**RE: Sydney Opera House Building Renewal Program – Concert Hall Upgrade and new Creative Learning Centre (SSD 8863)**

**Pauline McKenzie**  
**Executive Director**  
Heritage Division  
Office of Environment and Heritage  
**As Delegate of the Heritage Council of NSW**  
Date: 20 December 2018

CONCERT HALL 'AT REST' IMAGES

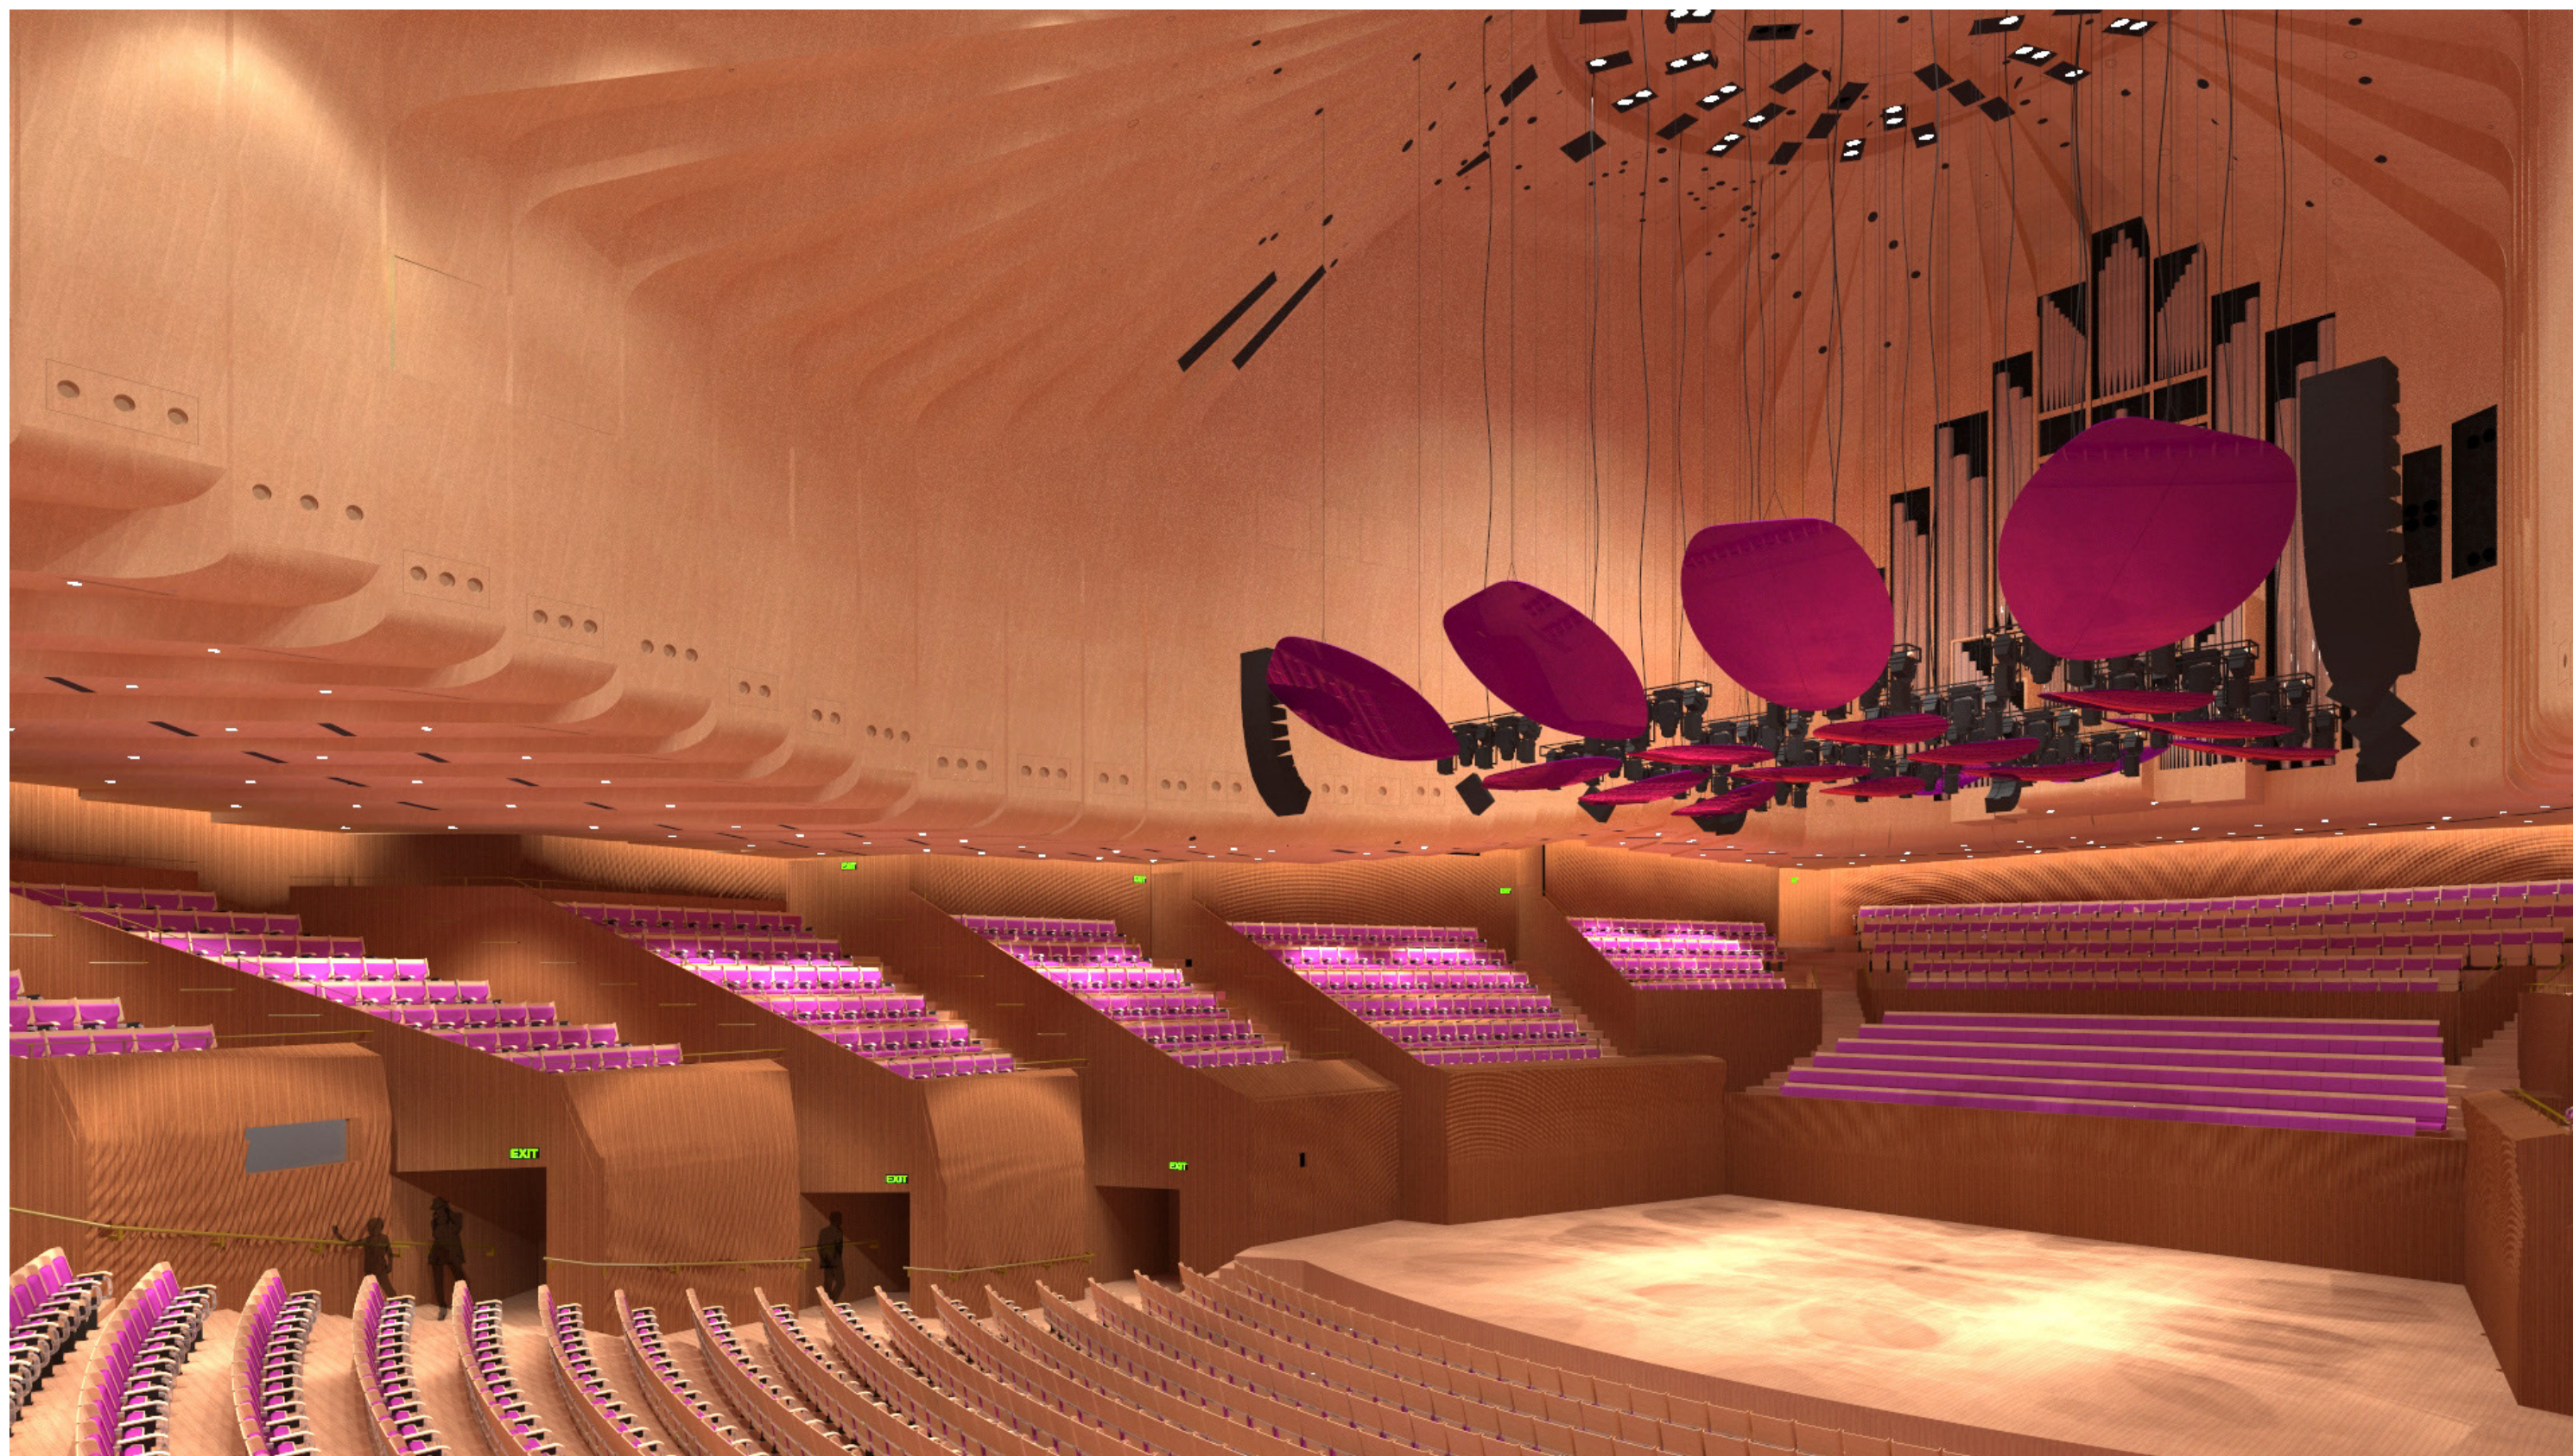
- The documentation should show and graphically illustrate, the various operational modes of the space to indicate the visual impacts of each mode (including at rest). This should also confirm that the 'at rest mode' clearly enables direct vision of the organ and pipes ensemble, the folded and domed ceiling forms and the timber finishes which were significant Peter Hall design elements.
